Our Case Number: ABP-317121-23

Re: BusConnects Swords to City Centre Bus Corridor Scheme
Swords to Dublin City Centre

ABP case ref: 317121

BUSCONNECTS SWORDS CORE BUS CORRIDOR SCHEME

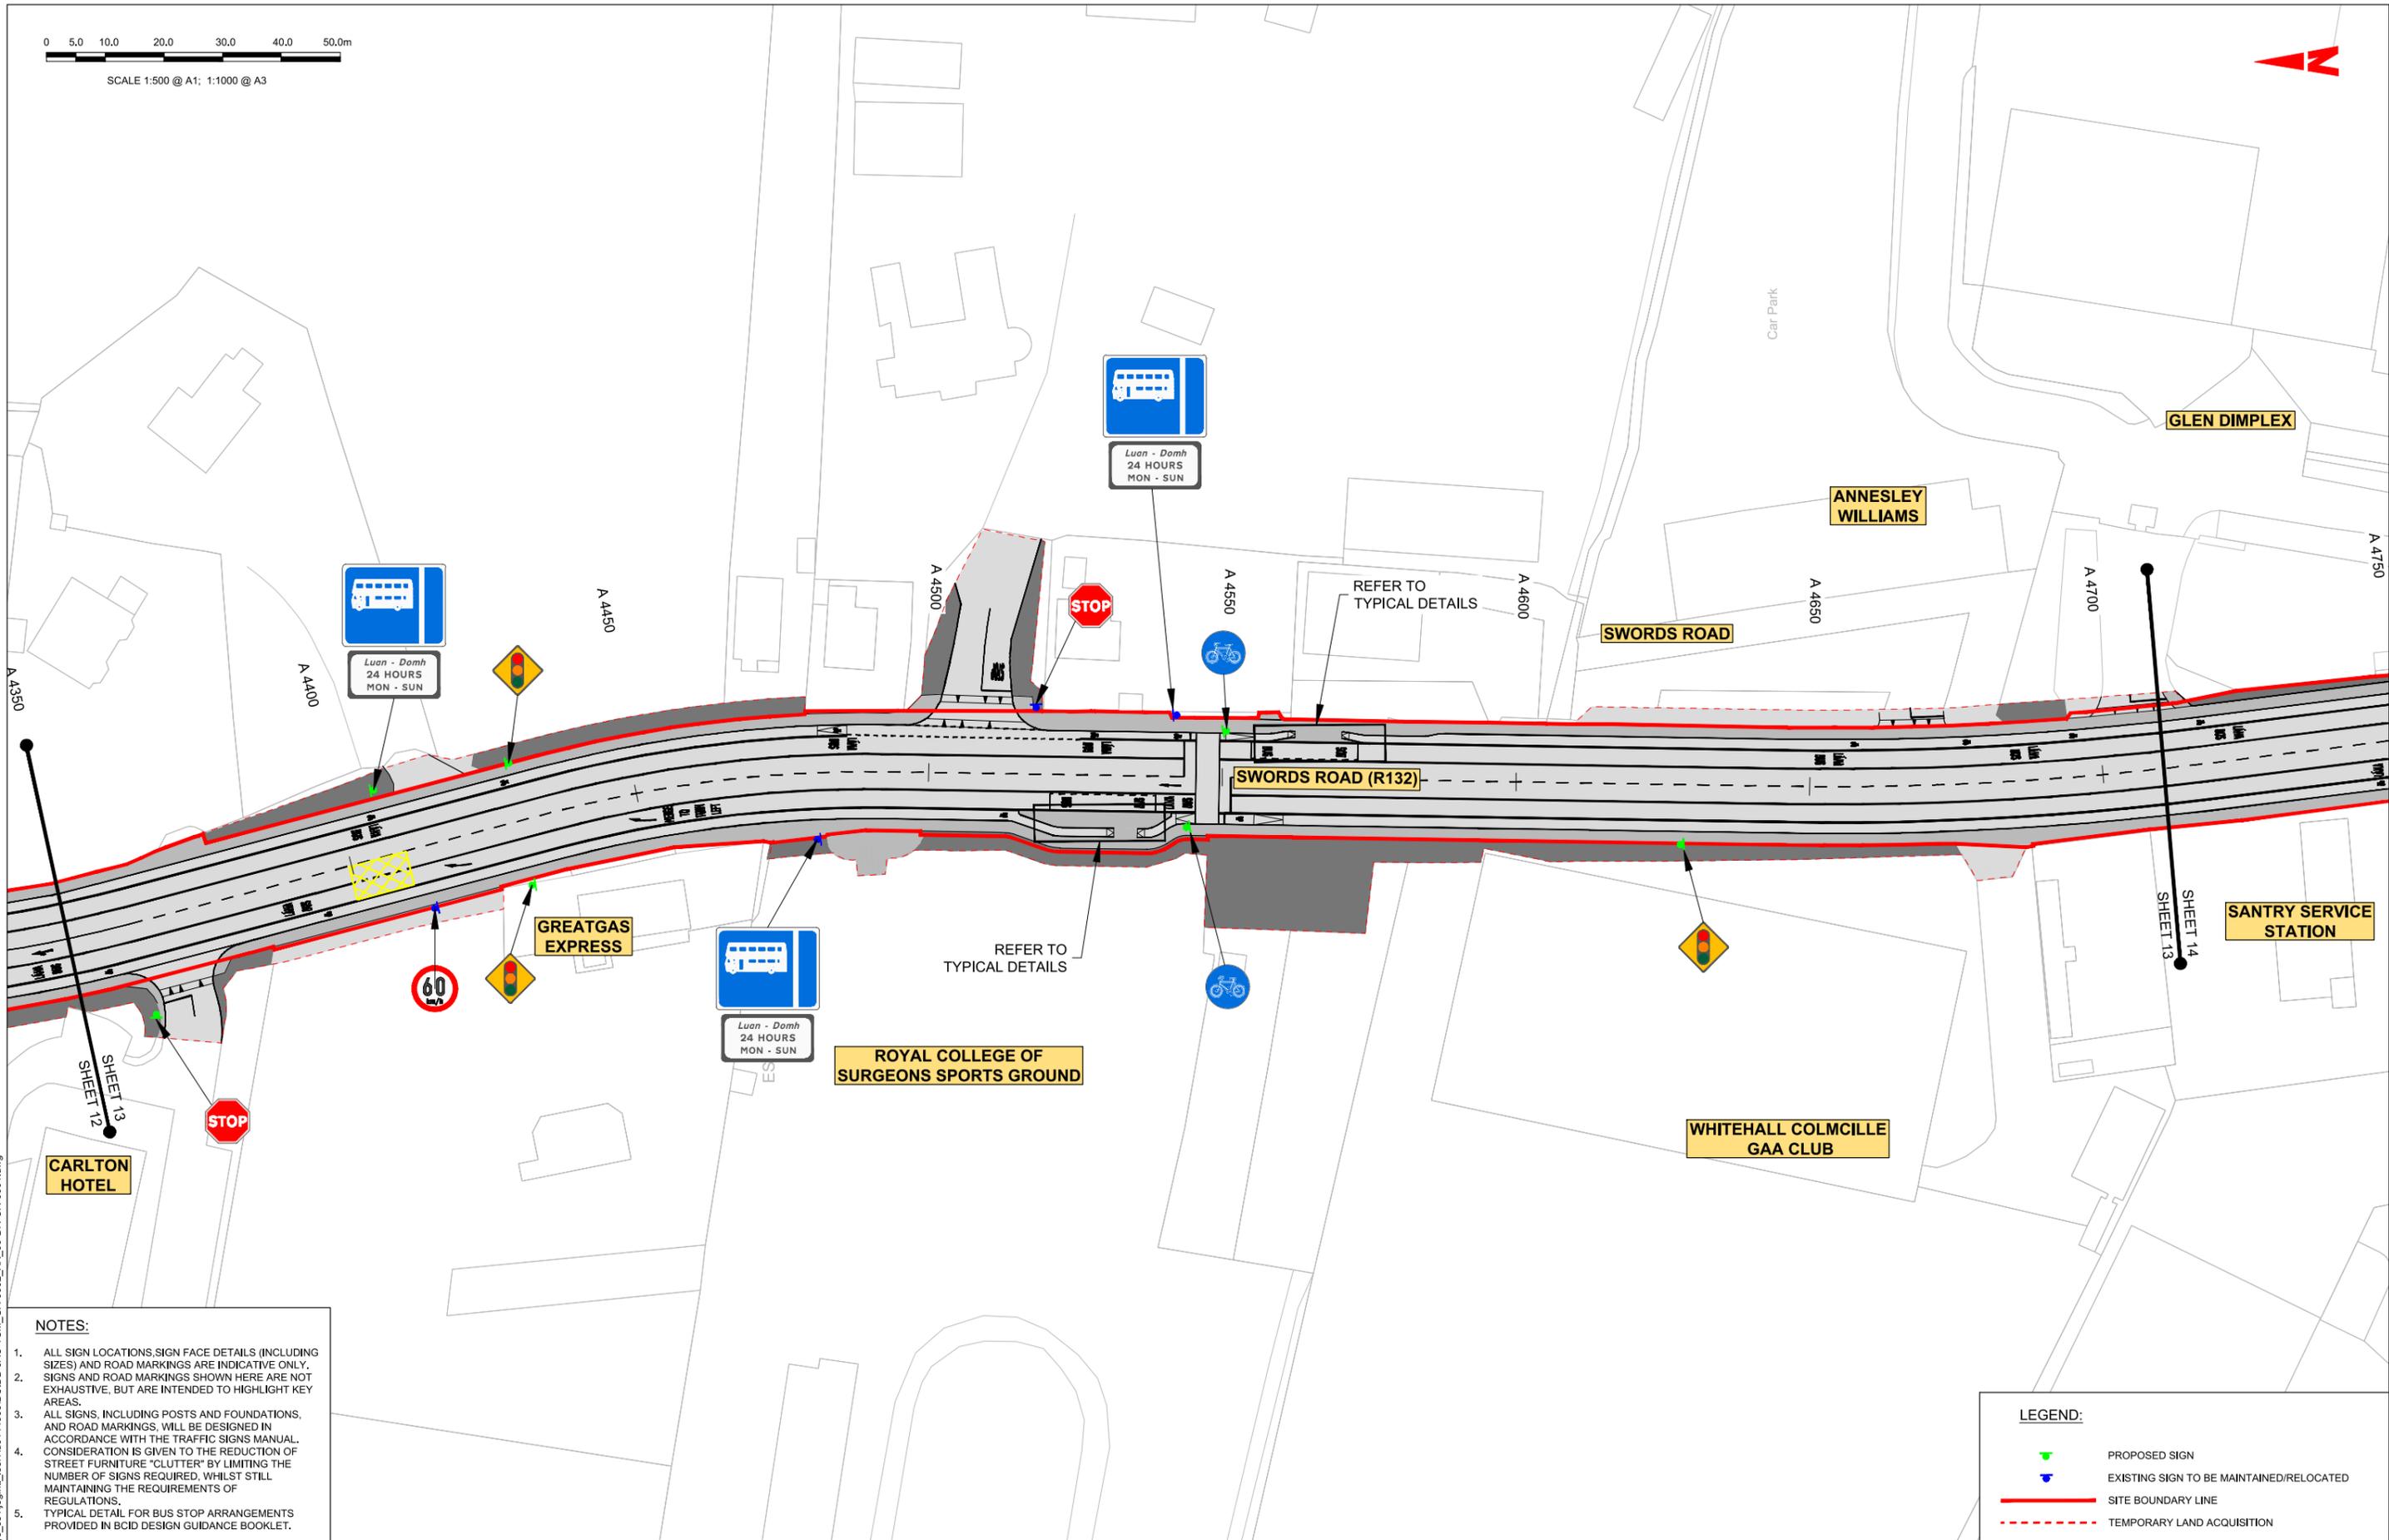
- Pinnock Hill Roundabout (sheet 1)
- Airside Junction (sheet 3)
- Cloghran Junction (sheet 6)
- Green Long Term Car Park (sheet 9) — 3 and 4 stage crossings with slip lanes
- South Corballis Road (10)
- Old Airport Road (12)

- Kettles Lane (sheet 5)
- Cloghran Junction (6)
- Long term parking/Kealy's Pub (9)
- Old Airport Road (12)
- Quick Park (12)
- Coolock Lane (18)
- Seven Oaks (28)
- Millmount Ave (31)
- Botanic Avenue (31)
- Clonliffe Rd (33)
- Whitworth Rd (33)
- Belvedere Road (34)

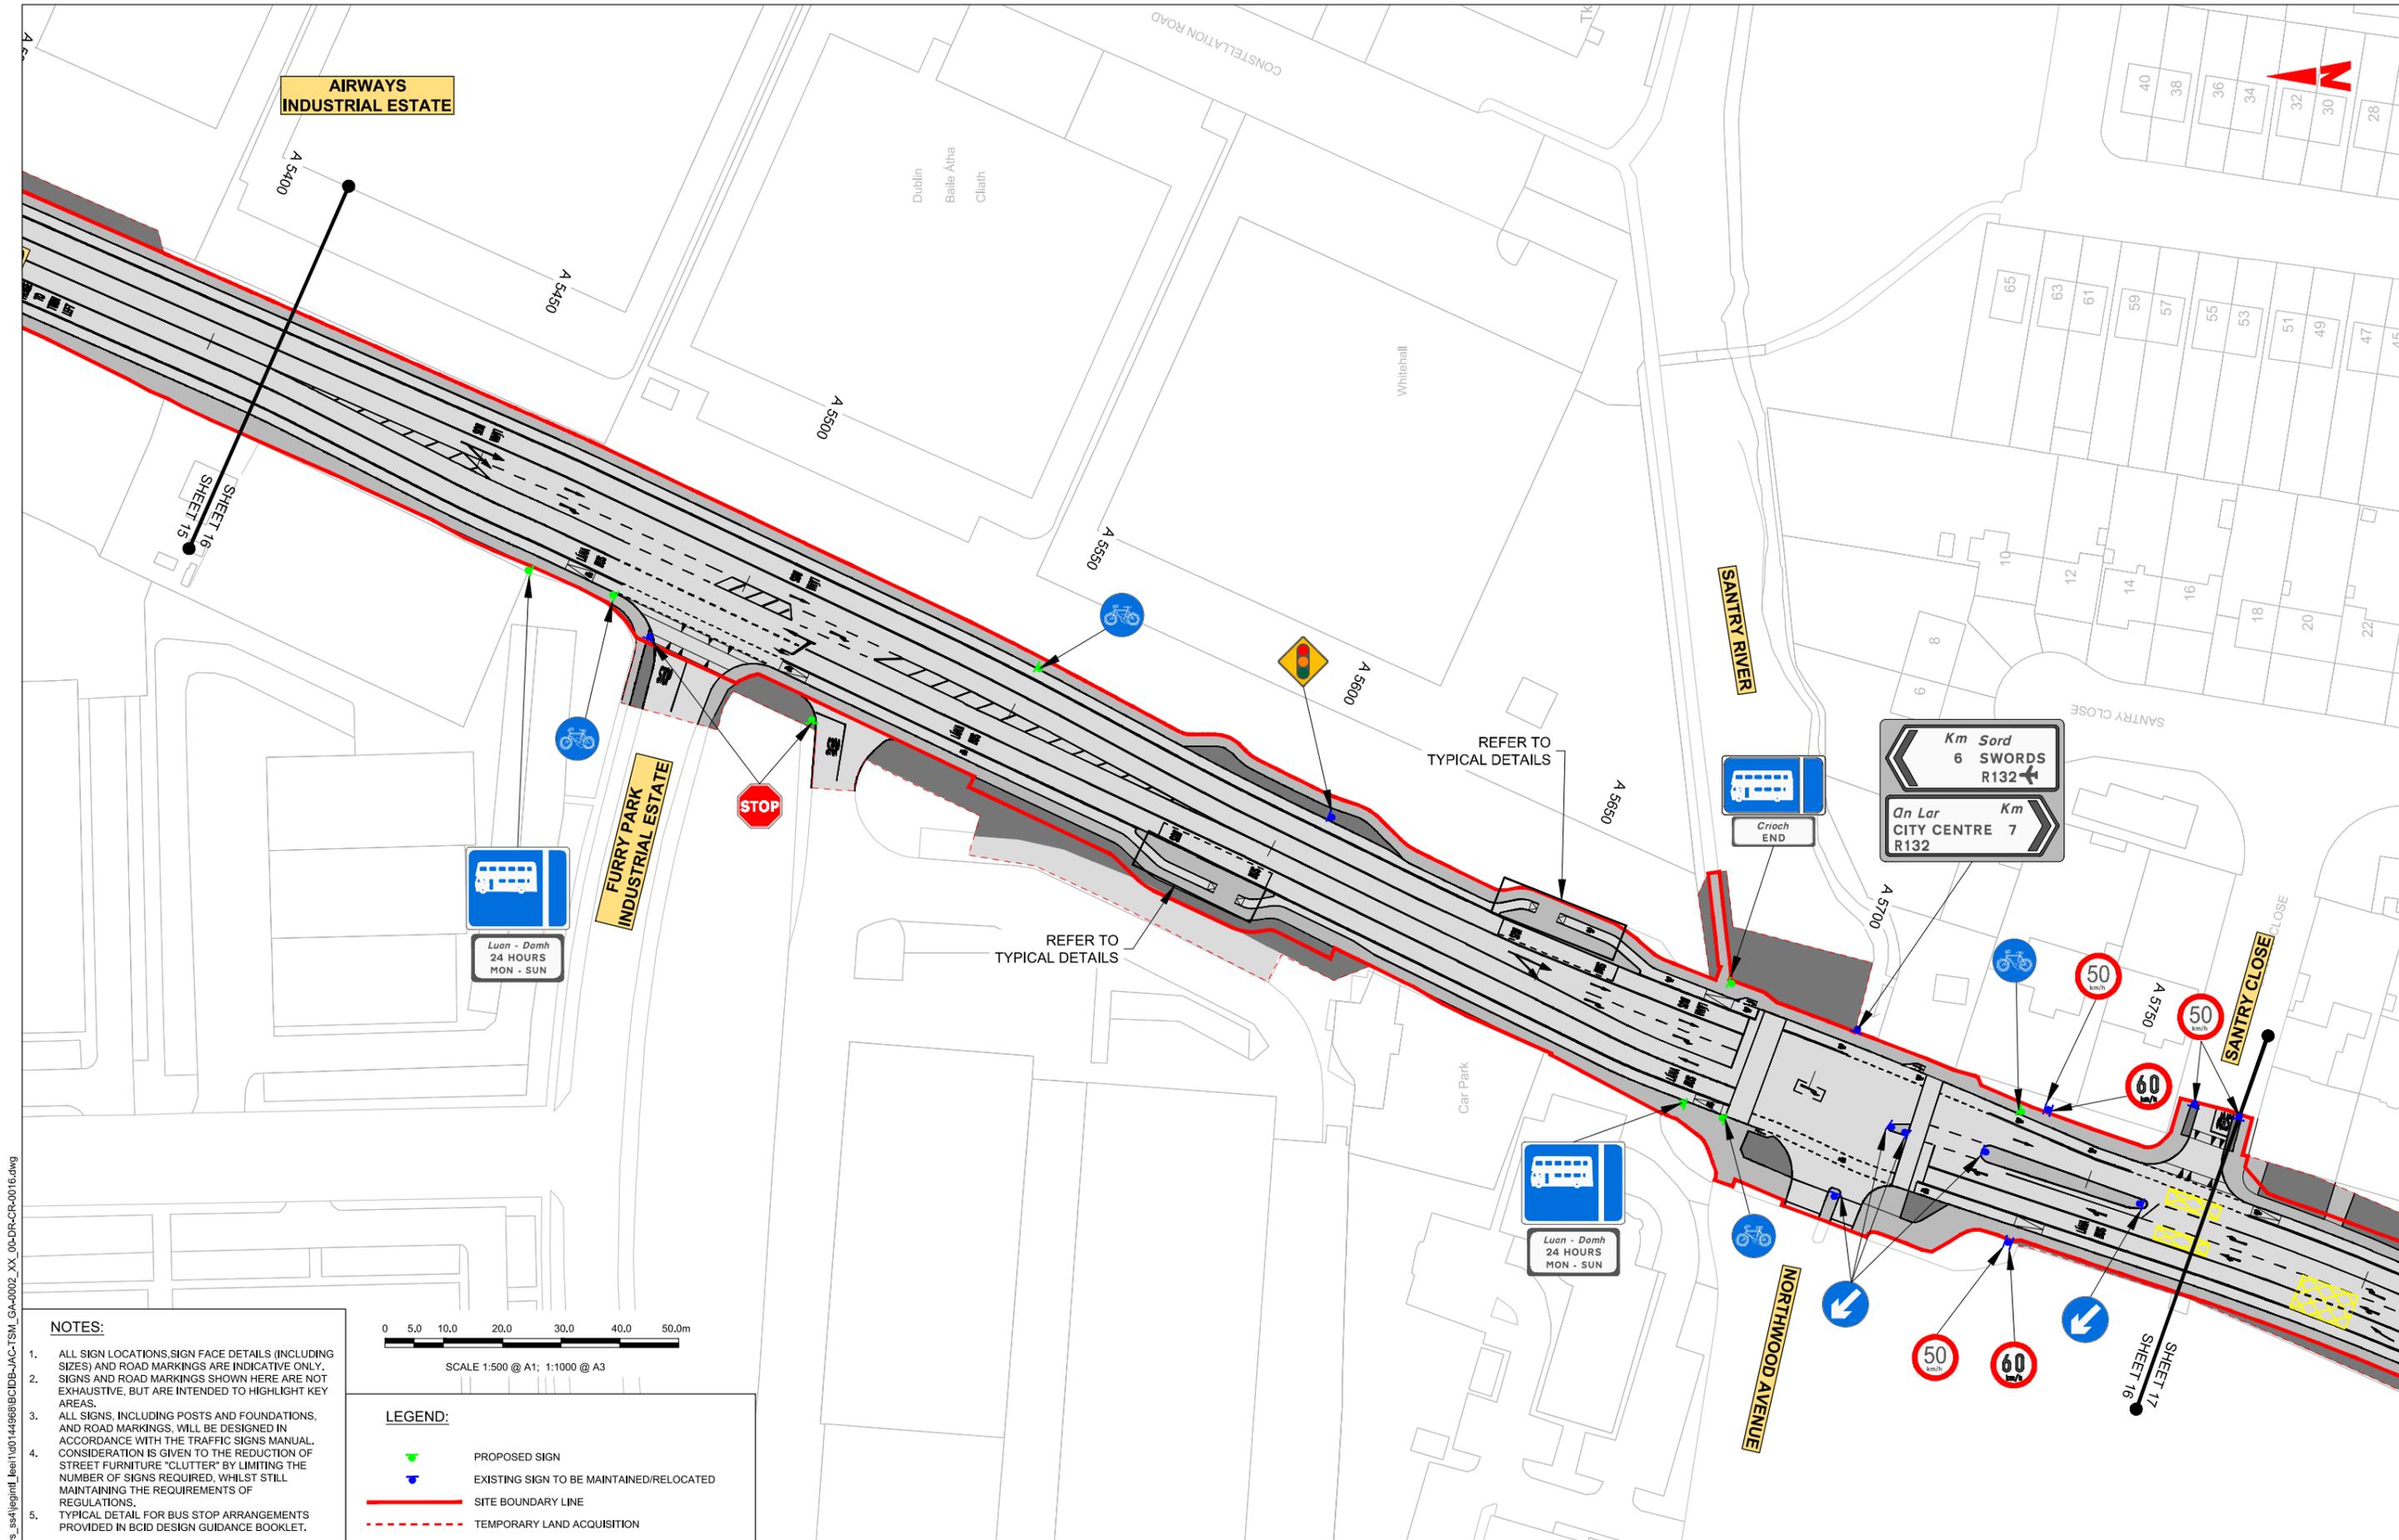
- Turnapin Lane (15)
- Coolock Lane (18)
- Santry Ave (19)
- Omni Shopping Centre (20)
- Collins Ave (25)
- Griffith Ave (28)
- Clonliffe Rd (33)
- Whitworth Rd (33)
- North Circular Rd (34)
- Gardiner St Upper (34)
